RFS

Your reference: SSD-71547218
Our reference: DA20240613002390-Response to
Submissions-1

**State Significant Development – Response to Submissions – Waste or resource management facility
1, 8 & 10 Styles Street & 145, 147 Mitchell Avenue Kurri Kurri NSW 2327, 3//DP586741, 1//DP1128108,
4//DP586741, 6//DP1251190, 1//DP1309128**

The NSW Rural Fire Service (RFS) has reviewed the *Kurri Kurri Integrated Resource Recovery Centre Response to Submissions Report* (Central Waste Plant Pty Ltd), prepared by EMM Consulting Pty Ltd (Alexandra Bishop, March 2026), including Appendix F (Report titled: *Updated Bushfire Consultant Response to RFS Submission*, prepared by Cool Burn Pty Ltd. Ref J317, dated 16 March 2026).

Residual Material Processing Shed - North Elevation  
Scale: 1 : 200

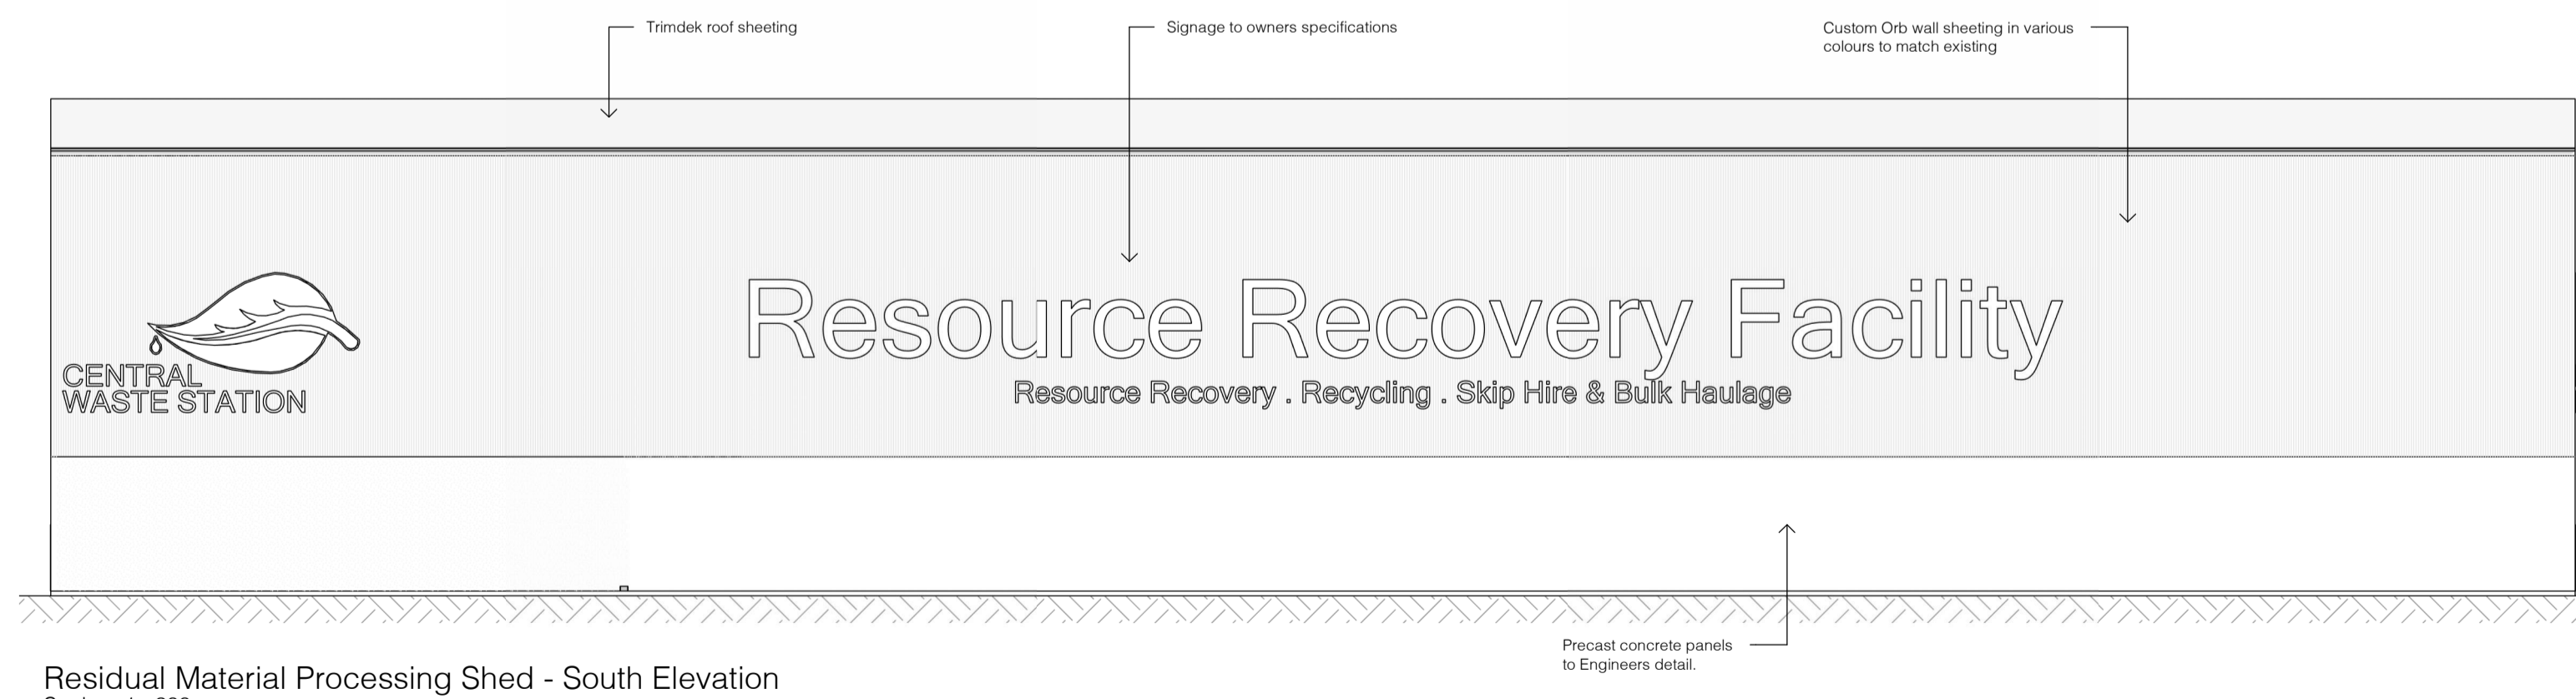
3. Proposed construction of the awnings, located over existing storage sheds, new processing shed additions (material bays) and the residual materials processing shed, must be undertaken using non-combustible materials.
